From: David Linton-Clowes <[REDACTED]>
Sent: 10 March 2023 10:42
To: Paul Cann
Cc: Simon Davis; Peter Cleveland; James Snelgar
Subject: RE: Planning Re-Consultation on: Y/53/22/DOC
Attachments: YAP-130-081 Drainage Layout Sheet 1 of 6 (Plots 1-23, 33-38) (rev C8).pdf;
YAP-130-082 Drainage Layout Sheet 2 of 6 (Plots 24-32) (rev C9).pdf; Appendix A -
As Built Contractor Letter.pdf

From: Paul Cann <Paul.Cann@arun.gov.uk>
Sent: Thursday, March 9, 2023 12:28 PM
To: David Linton-Clowes <[REDACTED]>
Cc: Simon Davis <Simon.Davis@arun.gov.uk>; Peter Cleveland <[REDACTED]>; James Snelgar <[REDACTED]>
Subject: RE: Planning Re-Consultation on: Y/53/22/DOC

I am writing to discuss the issue of storm drainage condition clearance at Yapton.

Drawing Title
DRAINAGE LAYOUT - PLOTS 1-23 & 33-38
38 UNIT SITE - SHEET 1 OF 6

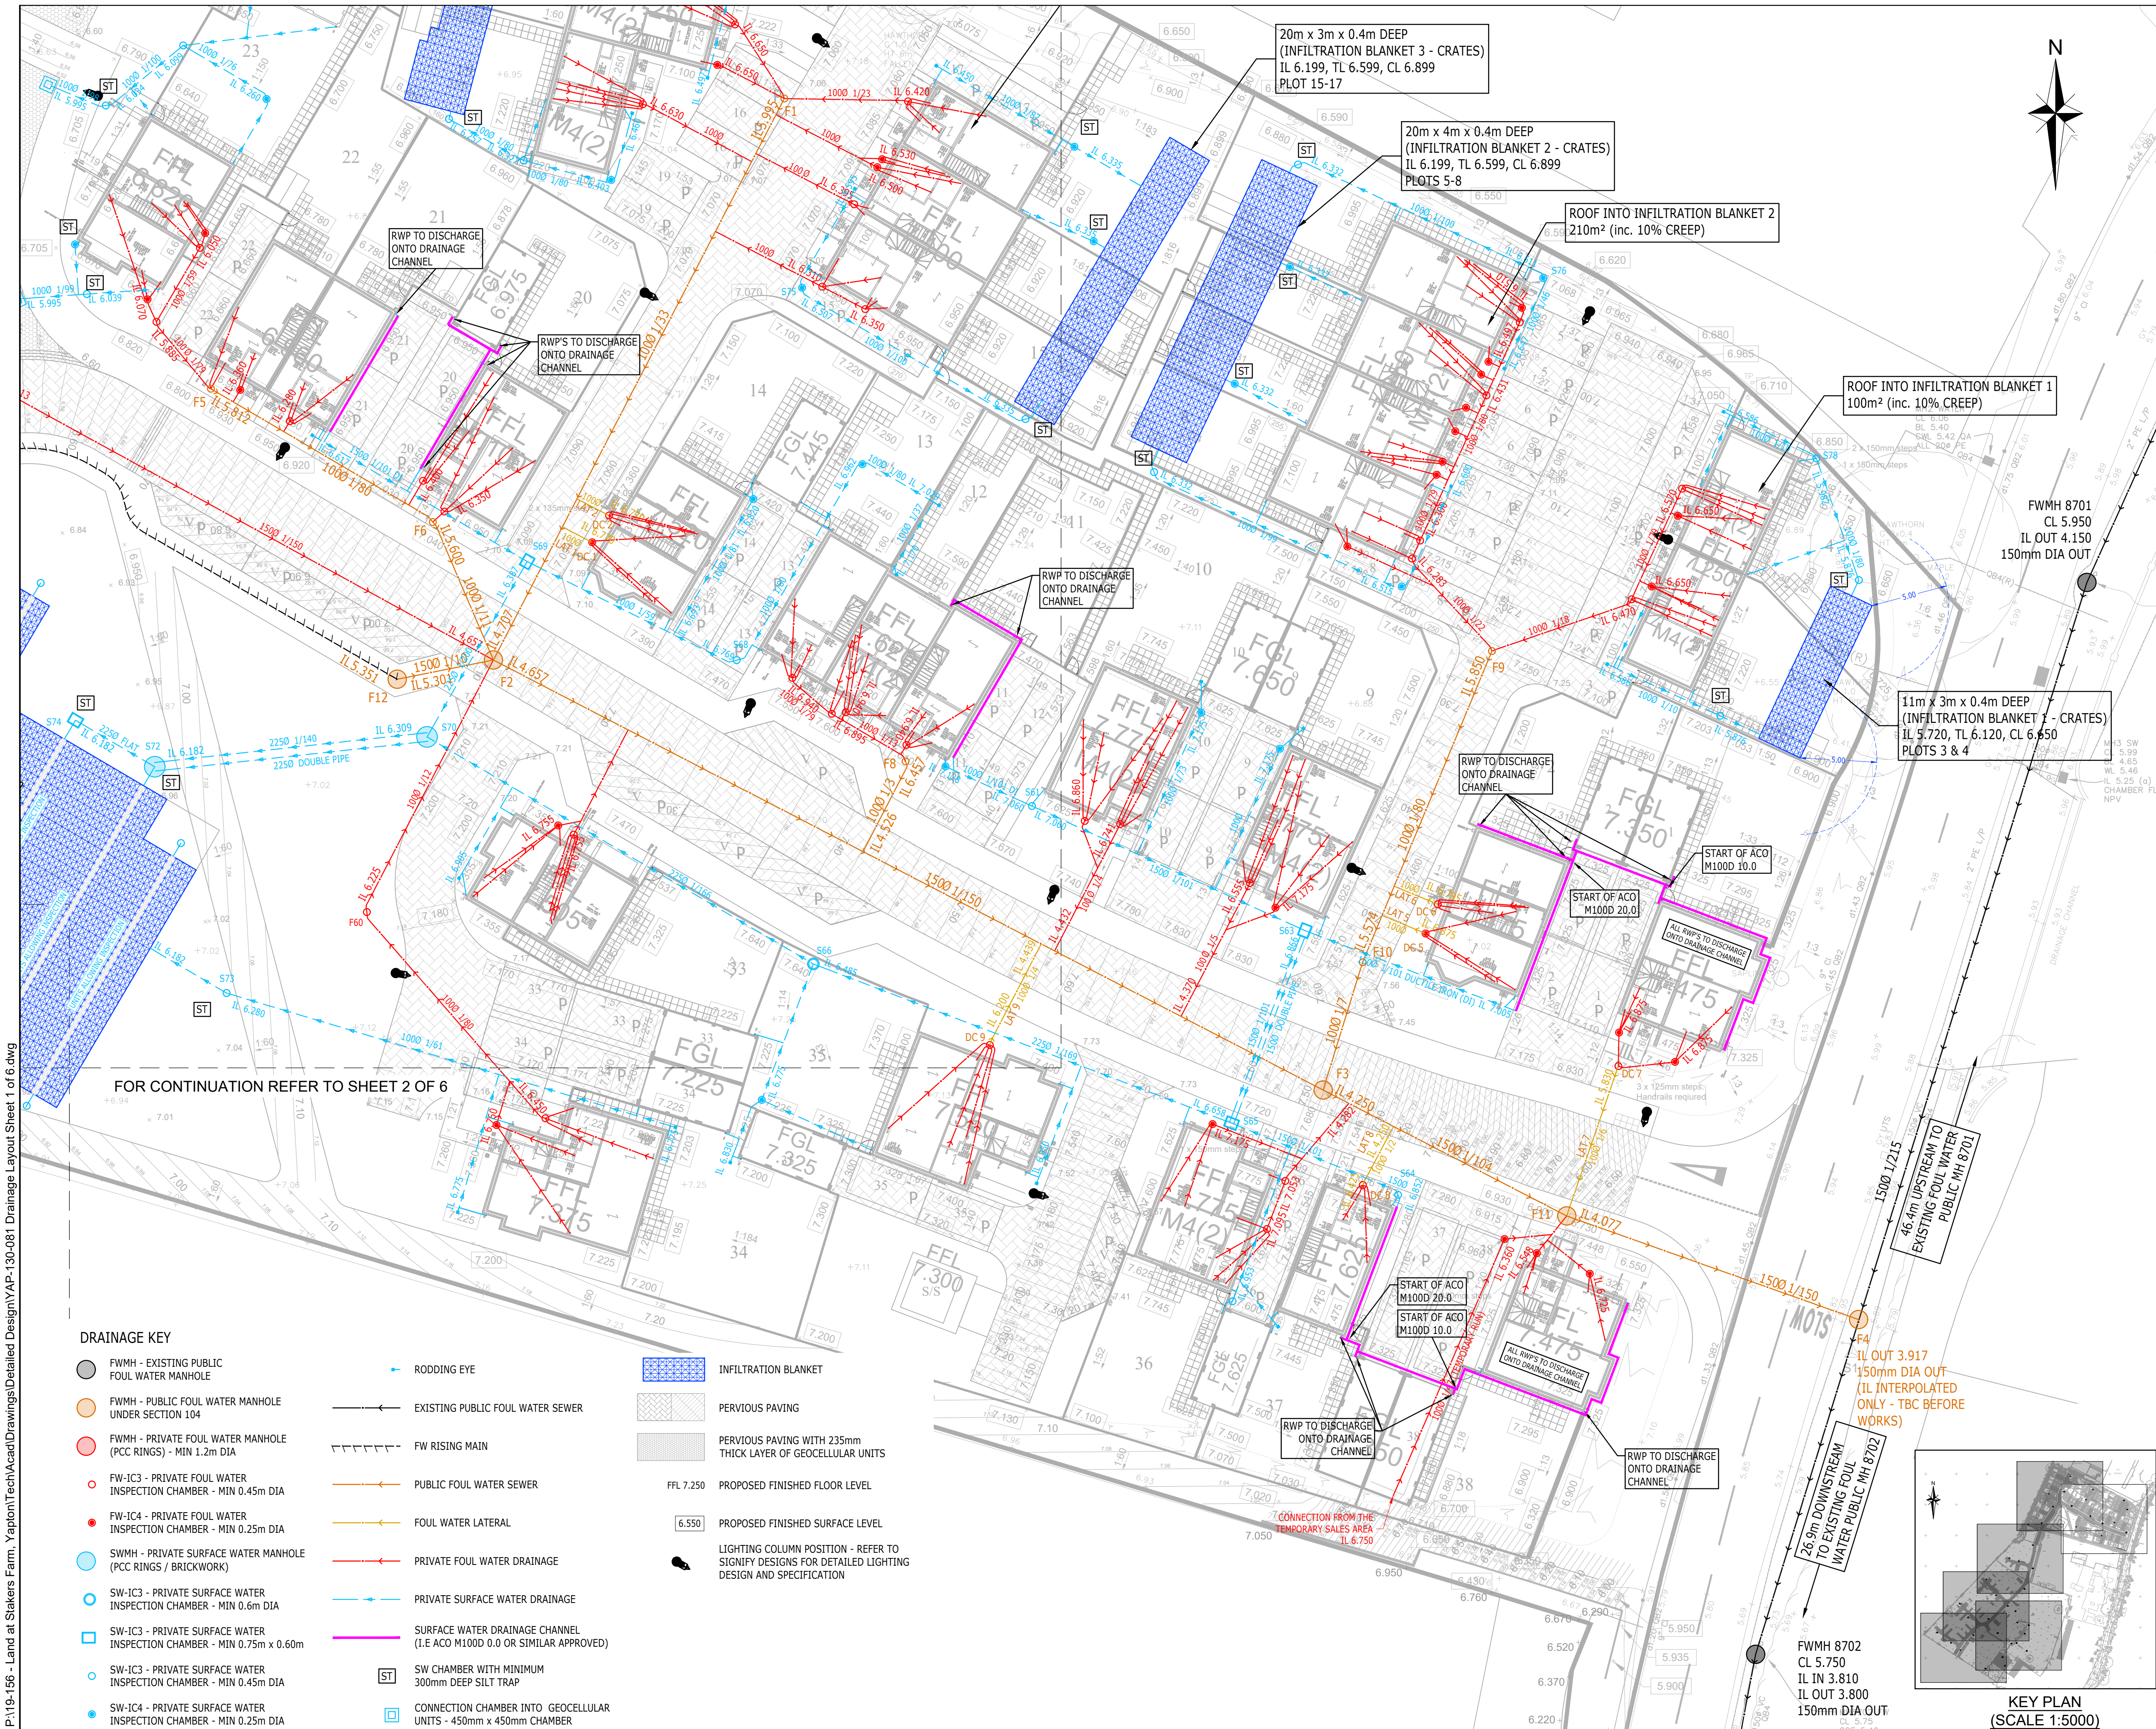
1. A copy of the contractors letter.
2. You mention the tank/tanks being located in plot gardens – are you sure this is the case? Please could you provide a drainage layout plan.

Please see attached drawings showing the tanks situated in the gardens.
The only other tanks are within the POS that have sufficient evidence already.
